Recommendation Report for Planning Permission for Works or Extension to a Dwelling

REF NO: LU/287/19/HH

LOCATION: 34 Tideway
Littlehampton
BN17 6QT

PROPOSAL: First floor side extension

1419/P03 A

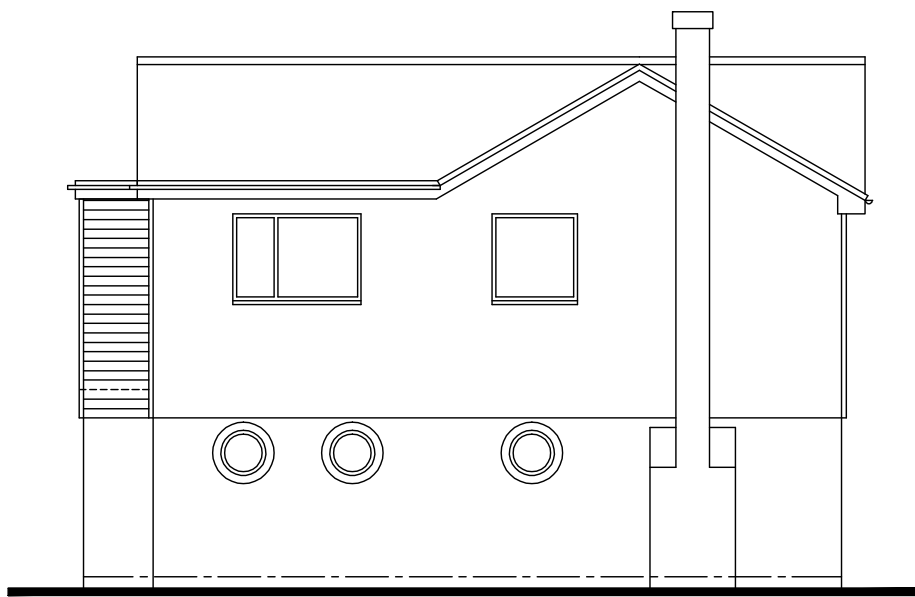
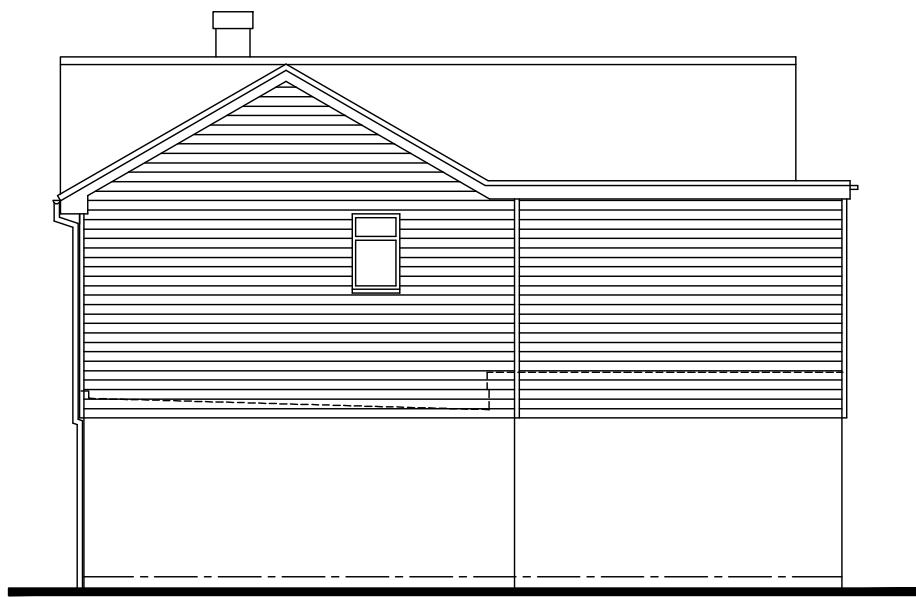
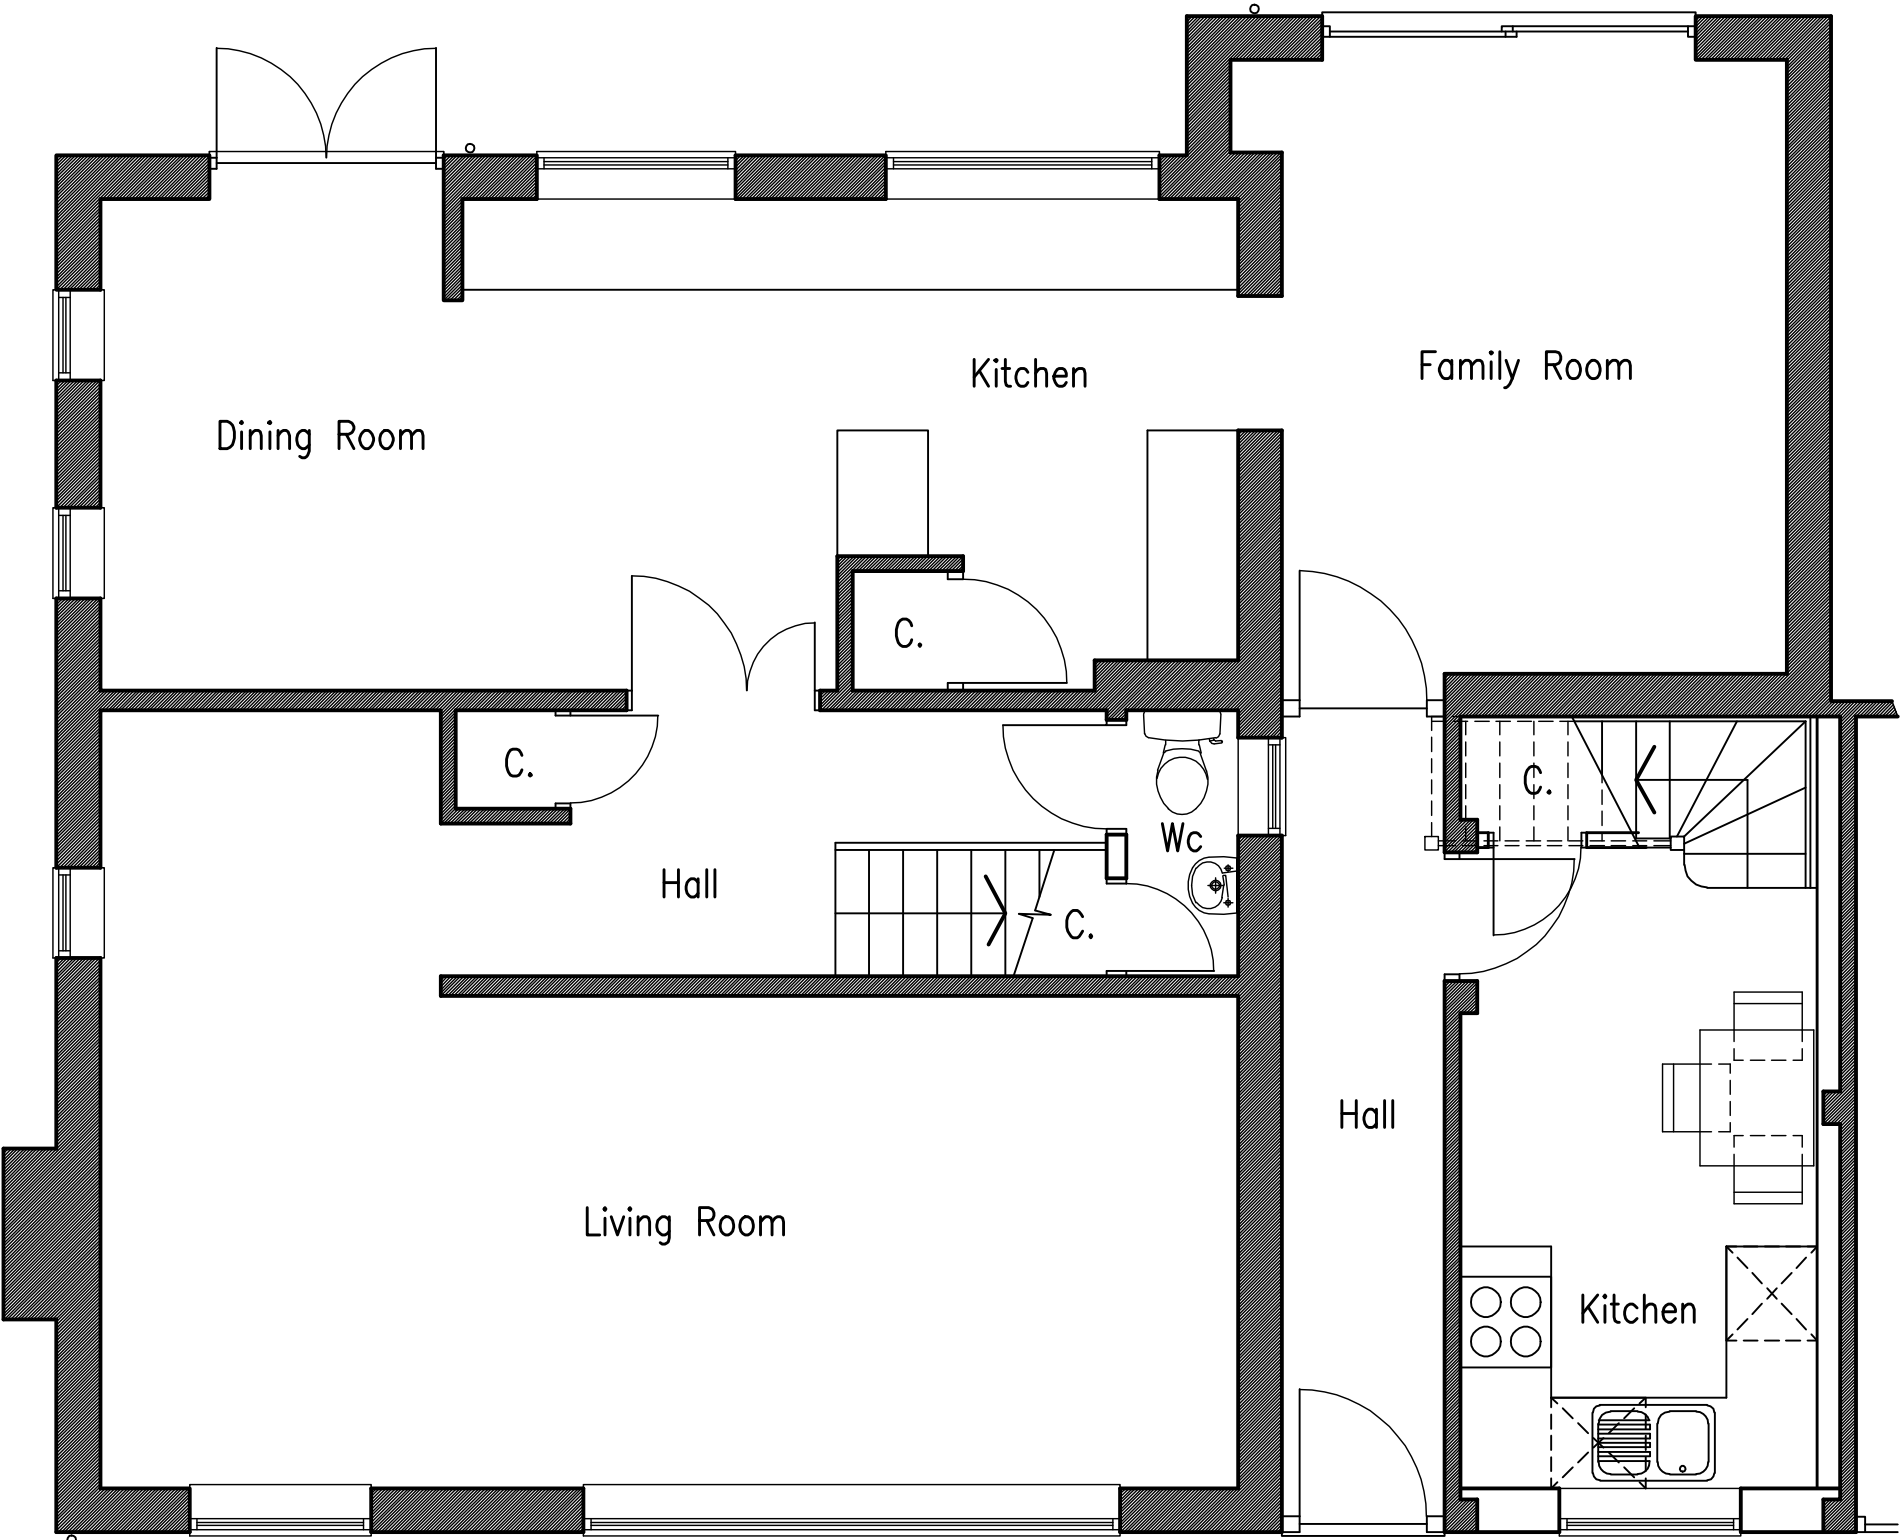
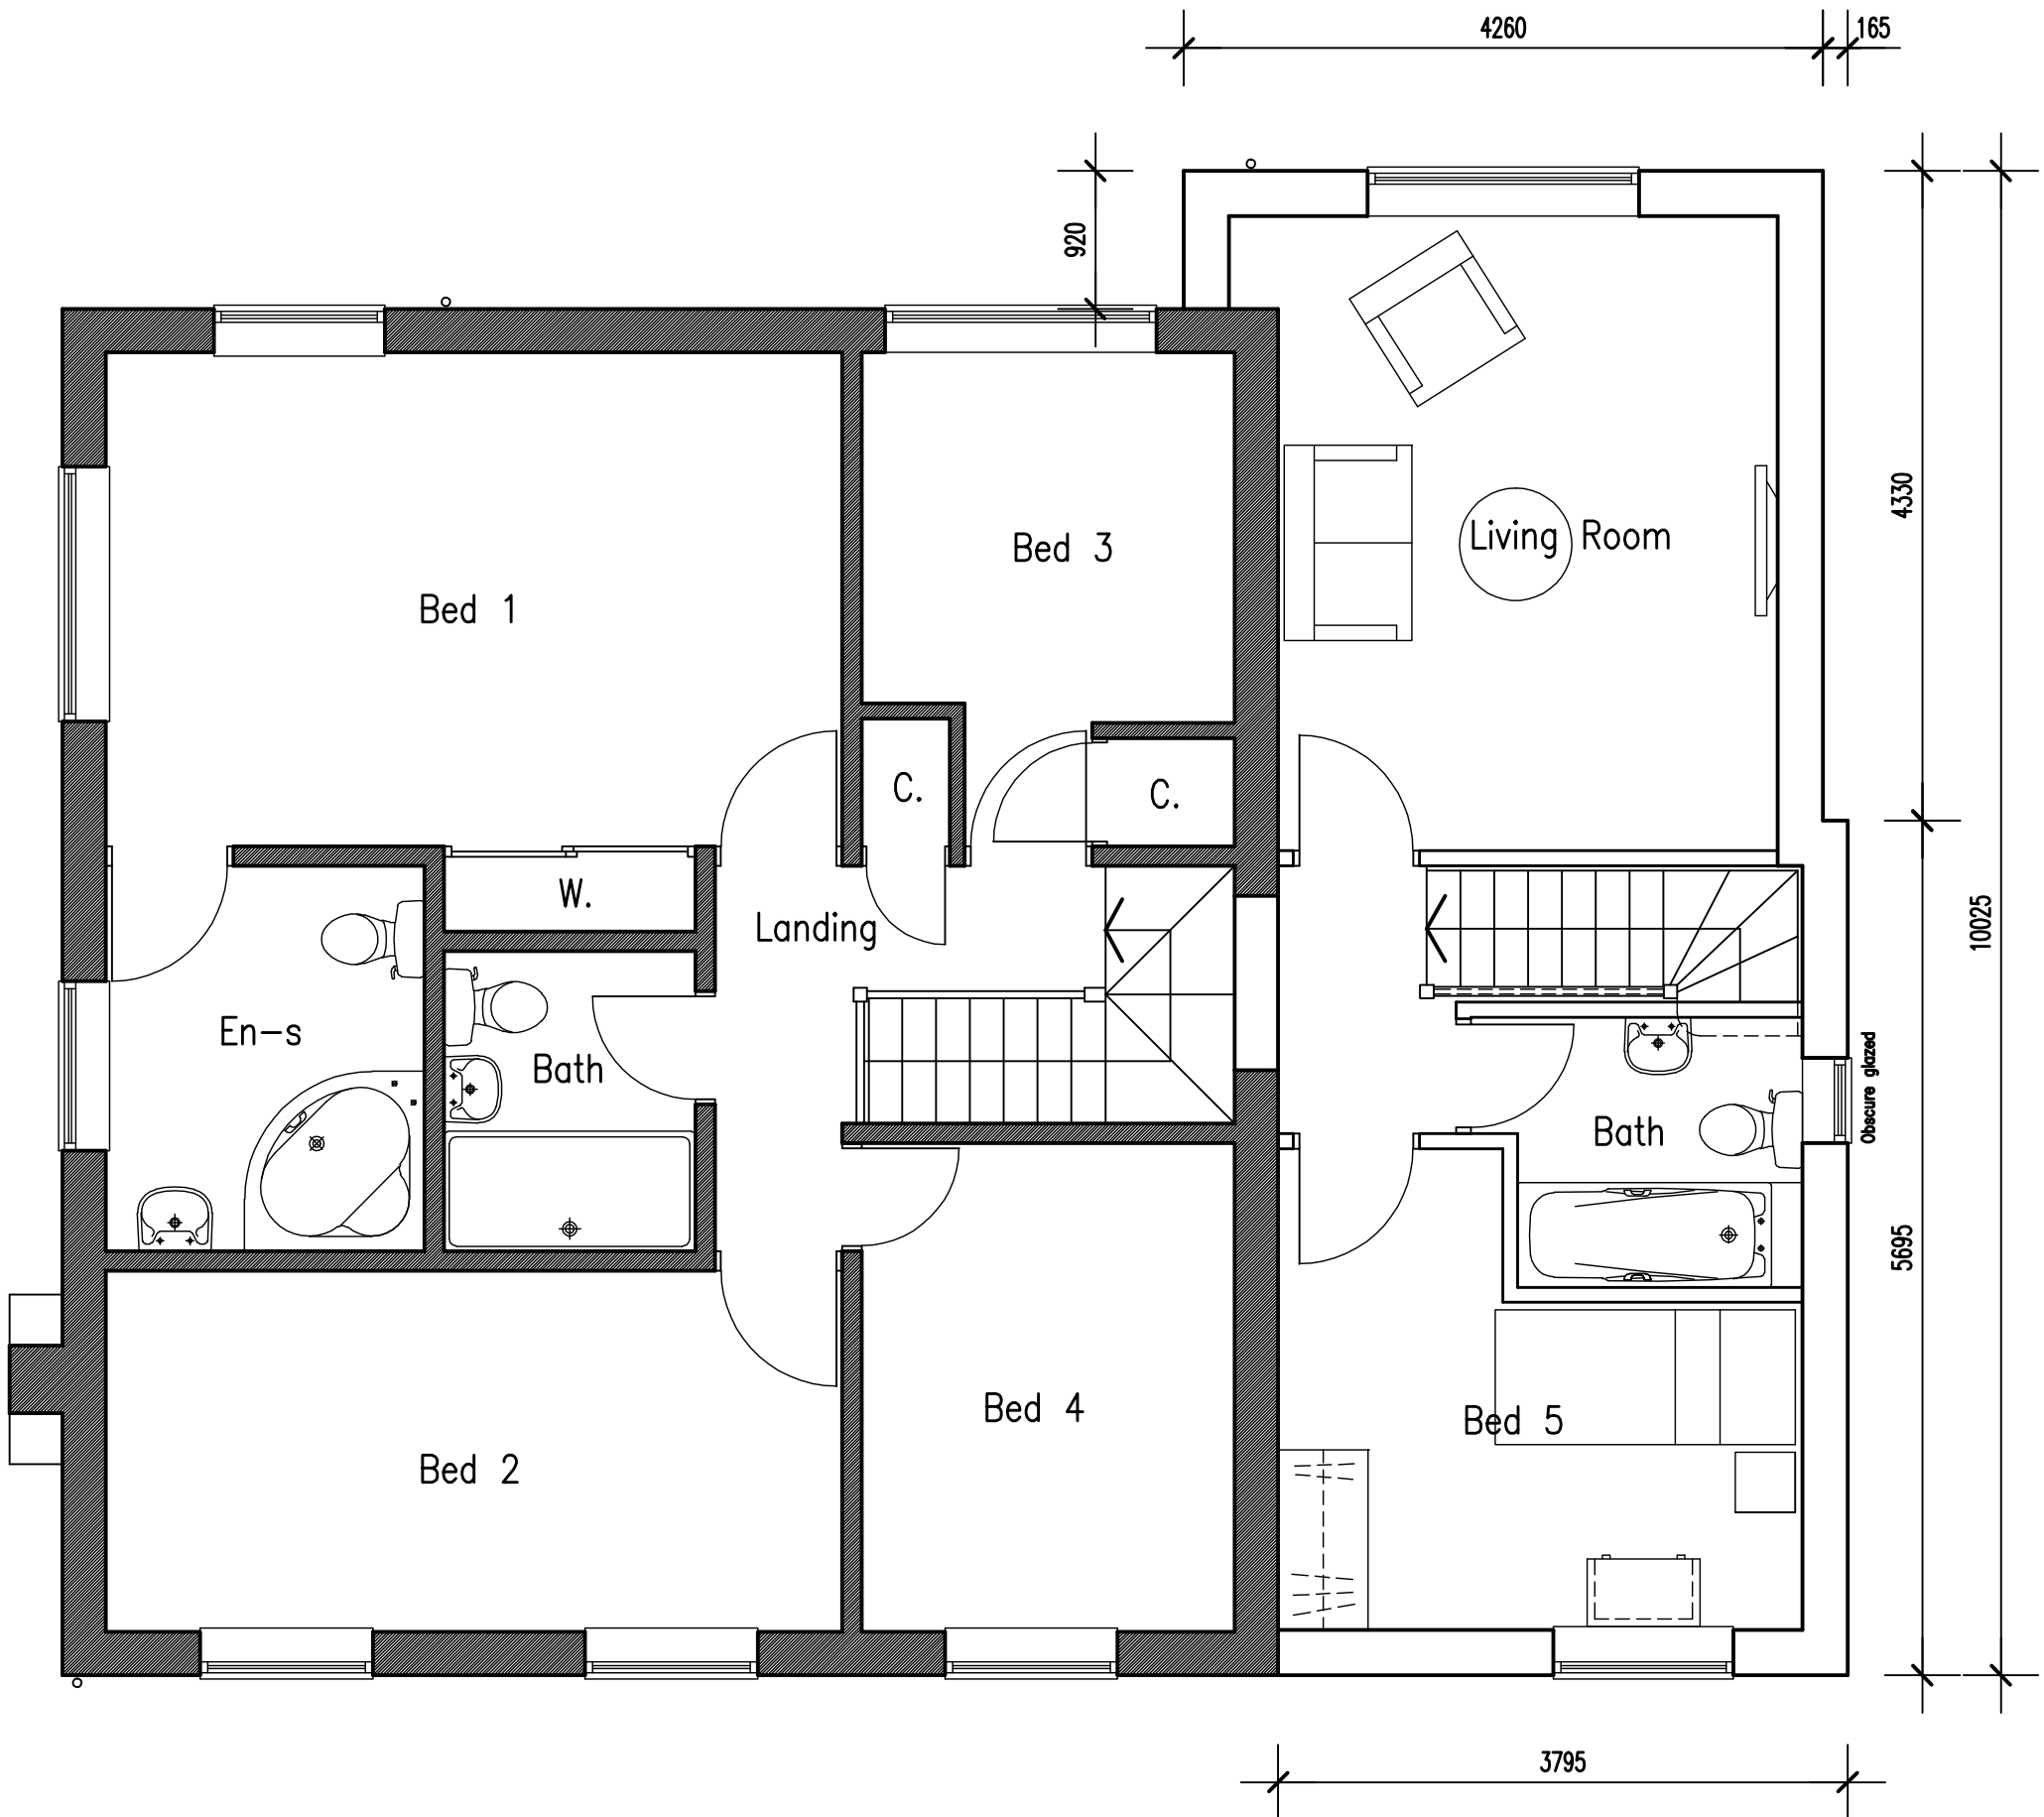
The proposed development is considered to result in a change of appearance of the host dwelling, as a result of the scale of the proposed extension. However, it is not considered to have a significantly detrimental impact on the established character of the host dwelling as a result of its design, scale and use of materials. It would be visually integrated well with the existing dwelling and would result in a sympathetic addition to the dwelling. Therefore, the proposed development is considered to be in accordance with D DM1(2), D DM4(a) and (b) of the Arun Local Plan.

The proposed extension is readily visible from the street scene given its prominent location. This is because the proposed development will not only be visible from the street scene of Tideway, but also Seagate Walk. However, there are other examples of similar side extensions within the location and it is not considered that the changes to this property will harm the spatial pattern of the area given the design of the proposed development, it is also considered to be well integrated with the host dwelling and resultantly, the development is not considered to be visually harmful to the established character of the area or the property. The proposed development is therefore in accordance with D DM1 and D DM4(e) of the Arun Local Plan.

The proposed extension is not considered to give rise to any significantly adverse impact on the neighbouring dwellings. The impact of overlooking from the rear is no worse than that resulting from the existing dwelling, there is 1 proposed window on the side (Northern) elevation of the extension, this is also considered to preserve the existing level of privacy, however due to the location and use a condition has been added to ensure the privacy of the neighbours. The siting of the extension is considered to be ample distance from adjacent dwellings in order to prevent any unacceptable overbearing or overshadowing at adjacent dwellings. Therefore, the proposed development is considered to be in accordance with D DM1(3) and D DM4(c) of the Arun Local Plan.

- 3 The window at the first floor level in the Northern elevation of the building shall at all time be obscurely glazed and non opening up to 1.7m above ground floor level.
